**Subject:** Notice of Exhibition for Barangaroo South 1A Subdivision (Third Phase) (SSD 8997)

From the information submitted, the following information has **not** been provided in the Plan of Subdivision as per the SEARs:

SUSSEX STREET

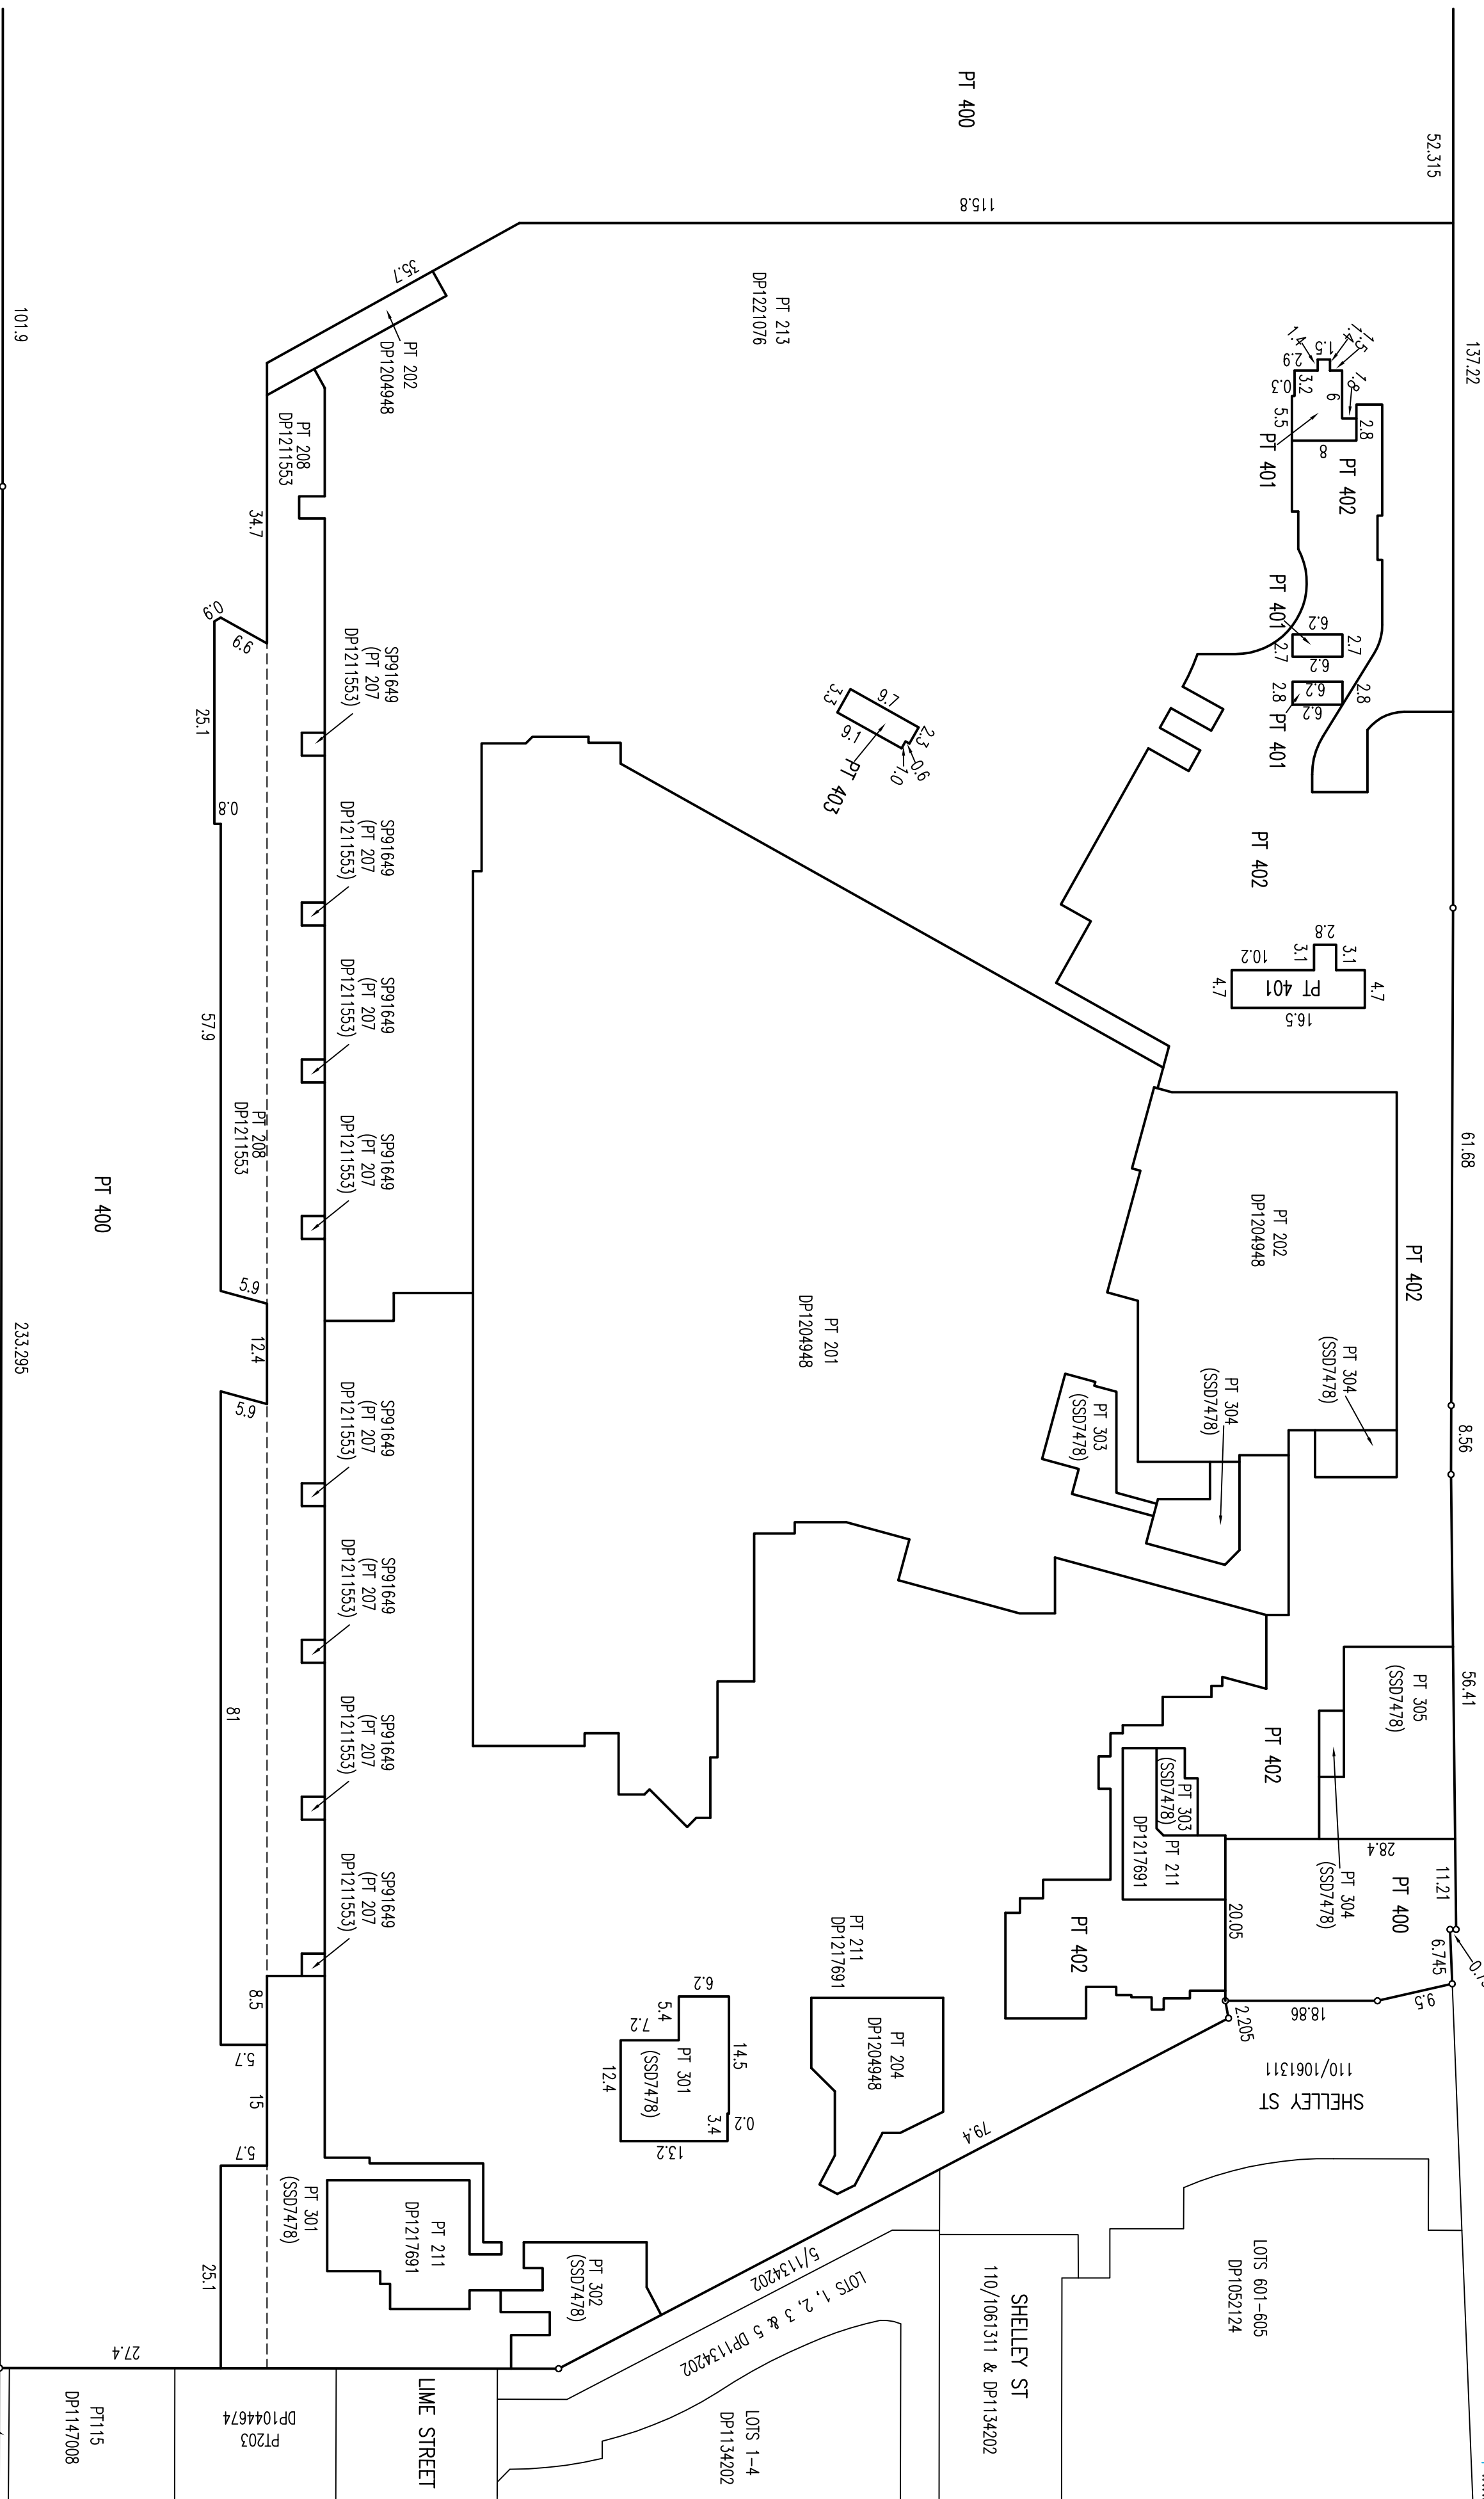
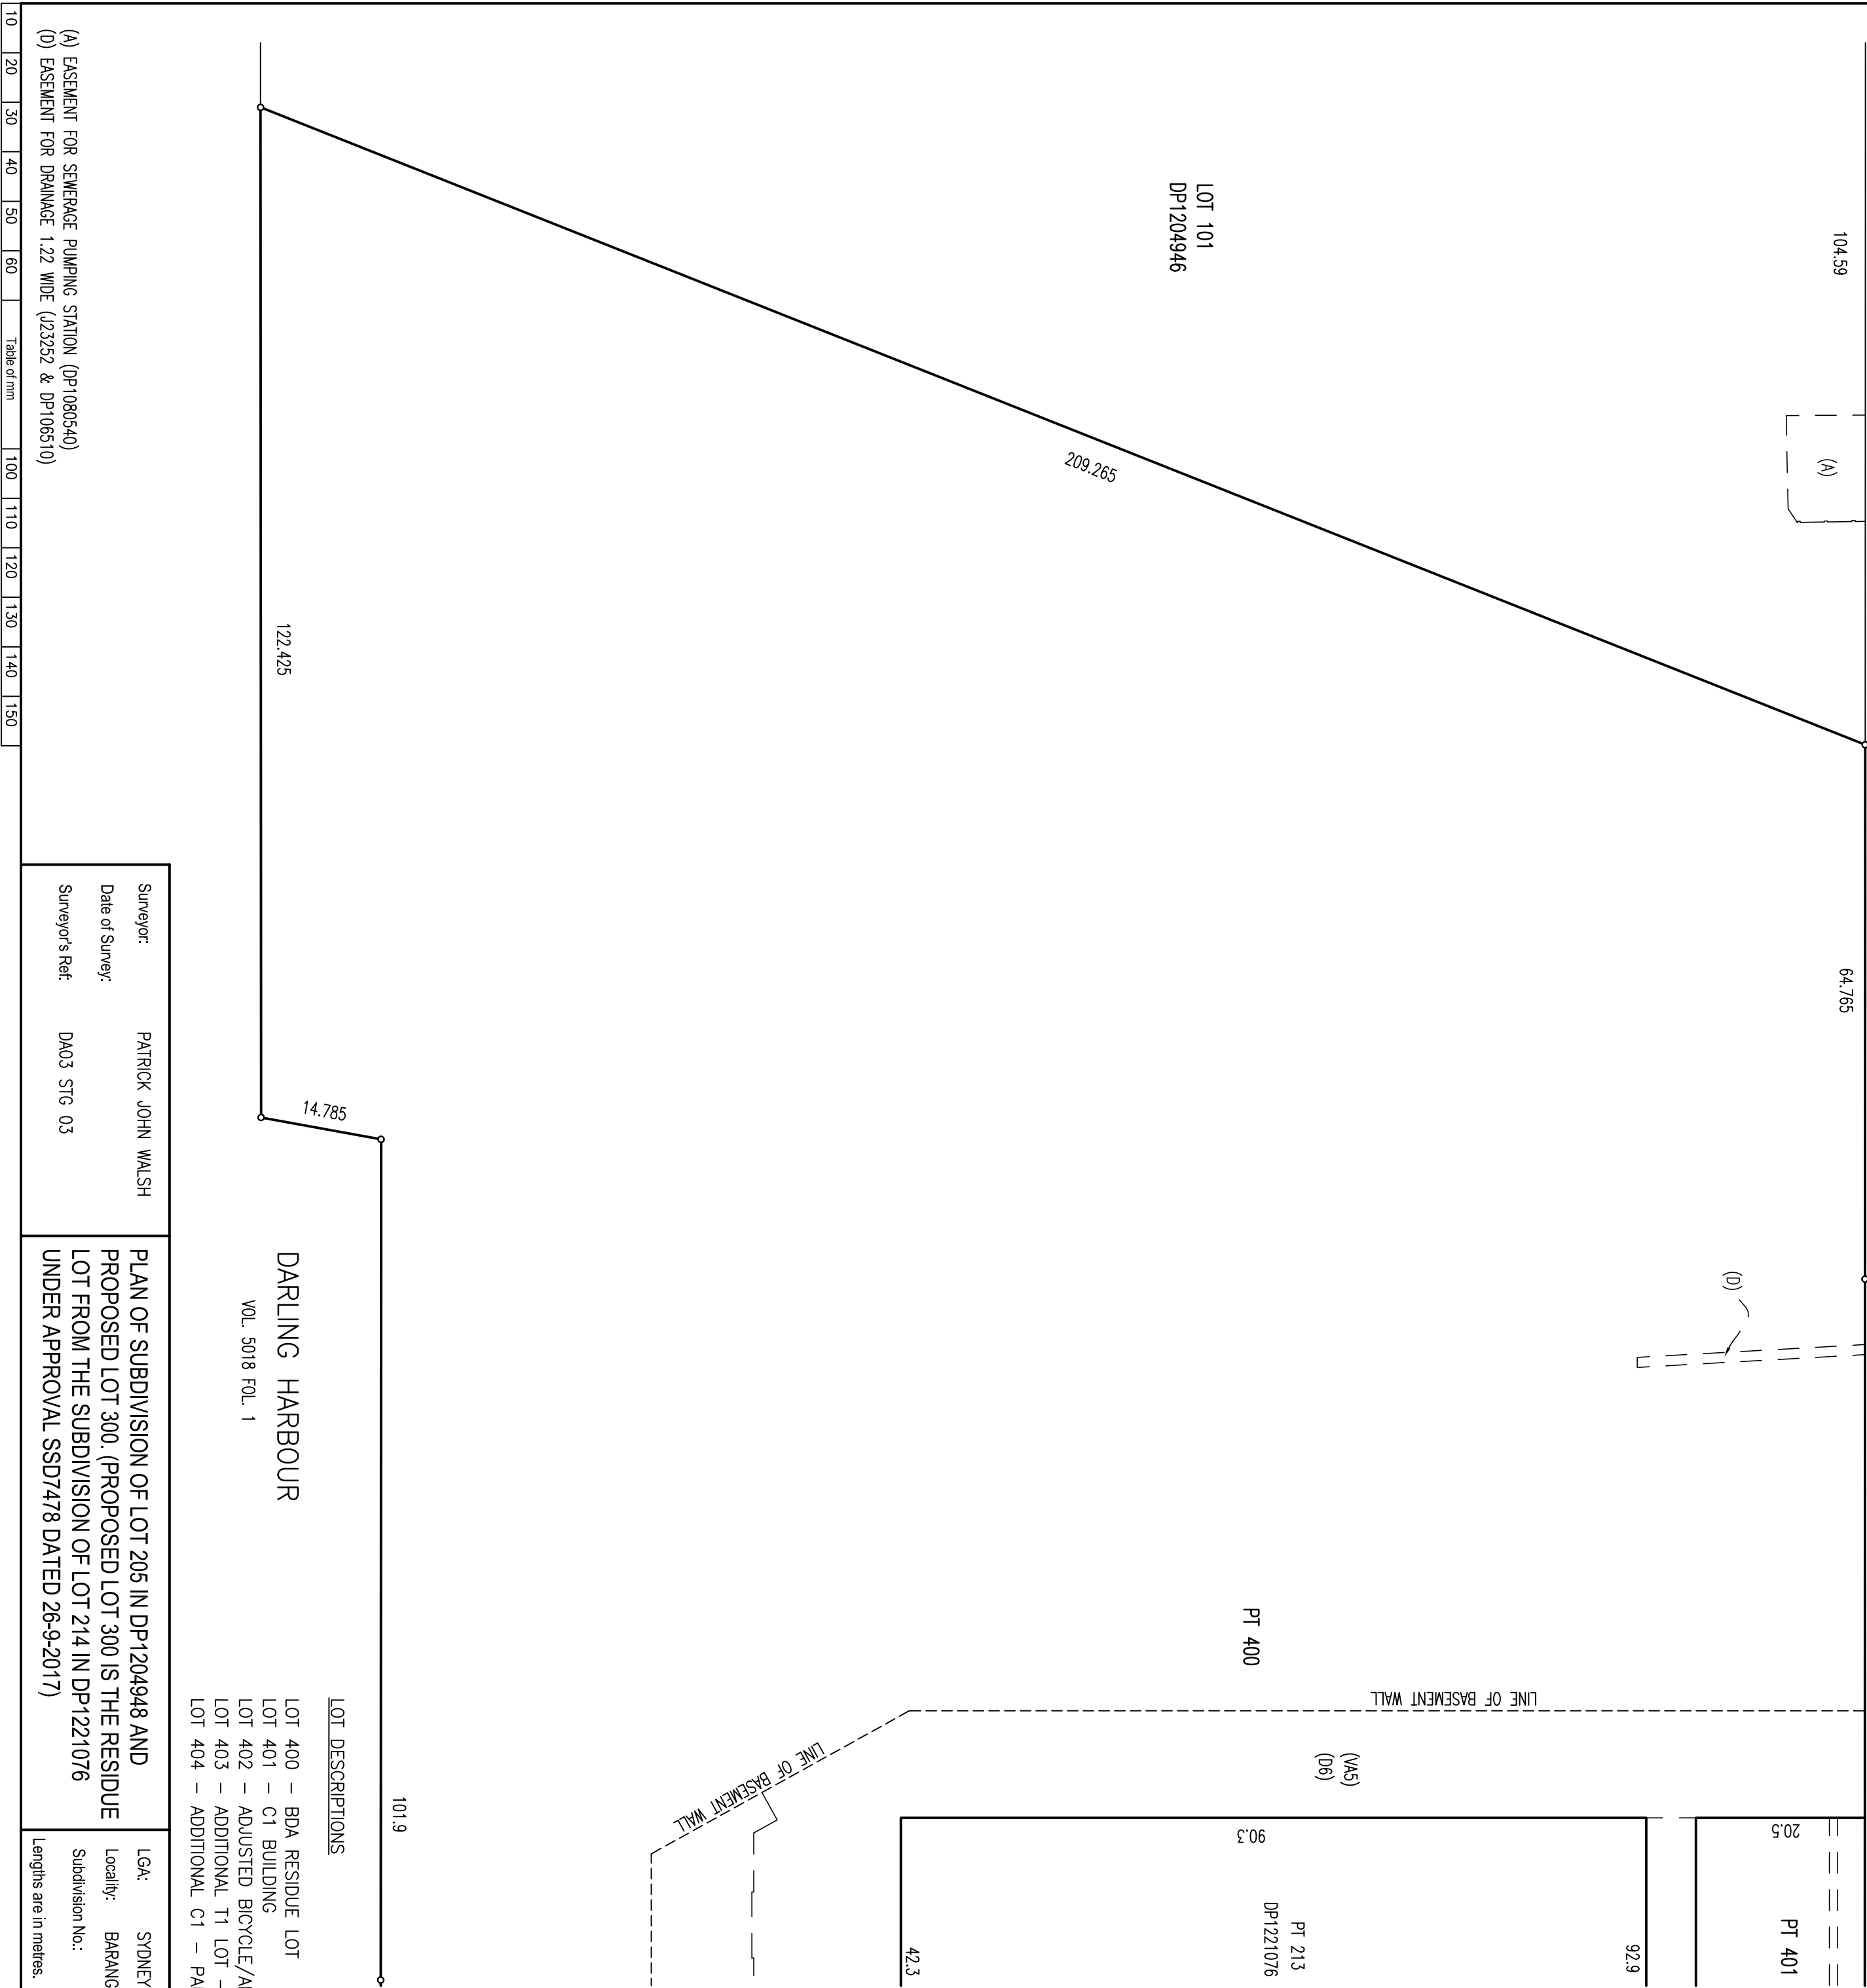
- **no details of any covenants, easements, notations, rights of way or the like proposed to ensure appropriate access is provided to each service provider to enable the on-going maintenance of their assets and to enable public access to the public domain areas have been provided and**
- **the information does not include a draft Section 88b instrument and a building management statement where relevant.**

The plans do not show any easements or covenants, therefore the Department should ensure:

- Compliance with SEARs.
- Compliance with previous approval for the development of the site. For example, full compliance must be given to the conditions of the SSD development consents contained within the Instrument of Approval, and as subsequently amended, in relation to the development of the subject site where applicable to this subdivision.

- Easements under Section 196 of Conveyancing Act: Documentary reciprocal easements for services, drainage, support and shelter, and emergency egress, affecting the whole of each lot if so desired, must be created over the lots in the subdivision, pursuant to Section 88B of the *Conveyancing Act 1919* and to Council's satisfaction.

- Additional easements: Any other documentary easements or any other encumbrances and indemnities required for joint or reciprocal use of part or all of the proposed lots as a consequence of the subdivision must be created over appropriate lots in the subdivision, pursuant to Section 88B of the *Conveyancing Act 1919* and to Council's satisfaction.
